Recommendation Report for Planning Permission for Works or Extension to a Dwelling

REF NO: LU/332/19/HH

LOCATION: 1 Swanwick Walk
Manning Road
Littlehampton
BN17 7FF

PROPOSAL: Single storey rear extension

| TITLE                                     |
|-------------------------------------------|
| Existing and Proposed General Arrangement |

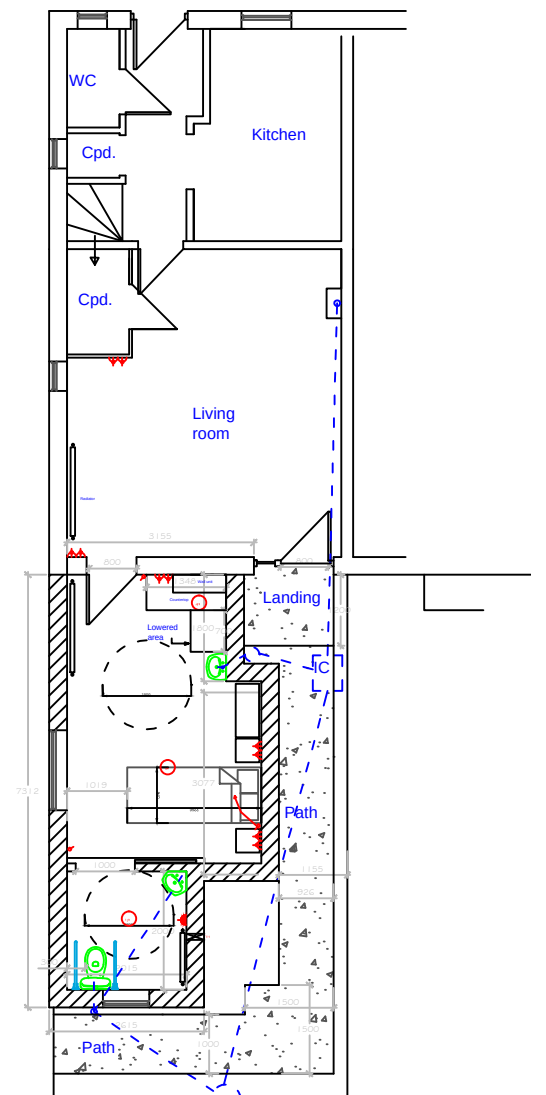
Due to its location, and the boundary treatment, the proposed rear extension is not visible from the street scene and therefore does not give rise to any unacceptable adverse impact on the character of the locality or the established pattern of the area. The maximum height of the proposal is 2.7m, and as such, is approximately 4m lower than the maximum height of the host dwelling. However, the proposal projects approximately 7.5m from the rear of the host dwelling, which is approximately 78% of the overall length of the host dwelling. As such, the overall footprint, and length of the proposal is considered to cause the proposed extension to not be subservient to the host dwelling. However, resultant of the aforementioned boundary treatment, the proposed development will not be visible from the public realm, and as such, considered to be an acceptable extension to the host dwelling.

The proposed development is considered to have a significantly harmful impact upon the residential amenities of the neighbouring dwelling. It is considered that as a result of the scale, and proximity of the rear extension to the North-Eastern boundary of the application site, it will have an unneighbourly and overbearing impact on the occupiers of the neighbouring property. The proposed extension is at a height of 2.7m, which is approximately 0.9m above the height of the boundary treatment. At a length of approximately 7.5m, this is considered to result in an unneighbourly impact upon the adjacent occupier, as it runs along the majority of the properties garden, albeit, set back. With regard to loss of privacy, all of the proposed openings are at ground floor level, and therefore, do not provide any views different to those available from the application site at current.

The proposed development is considered to be in conflict with D DM1(3) and D DM4(c) of the Arun Local Plan, due to its detrimental impact on the occupiers of the dwelling to the North of the application site, by

- 1 The proposal, due to its height and length, will have an unneighbourly overbearing effect on the occupiers of 2 Swanwick Walk, Manning Road in conflict with D DM1(3), and D DM4(c) of the Arun Local Plan and Policy 1 of the Littlehampton Neighbourhood Plan.
